CITY OF ALBUQUE

Planning Department
Brennon Williams, Director

**Re: Ventana Square - Paseo Del Norte/ Universe Blvd.
Erosion and Sediment Control Plan
Engineer's Stamp Date 10/29/21 (L10E007A)**

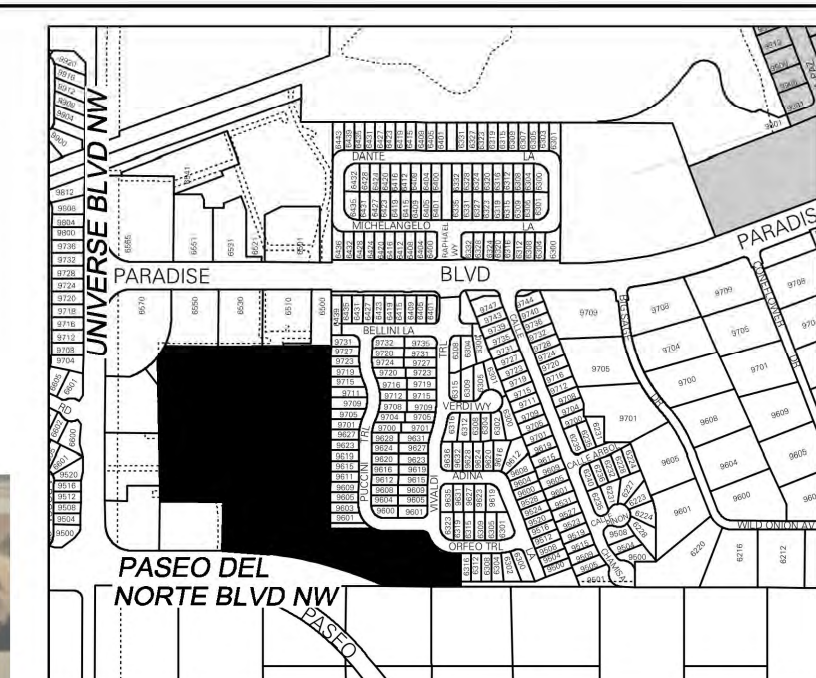
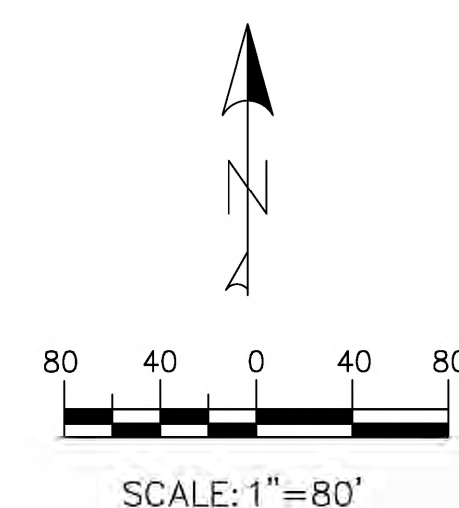
1. The pond is located on property owned by Ventana Ranch Community Assoc. Their NOI is required.
2. Add the limits of disturbance for the pond grading on the ESC Plan.
3. Add stabilization specifications for the pond to the ESC Plan.
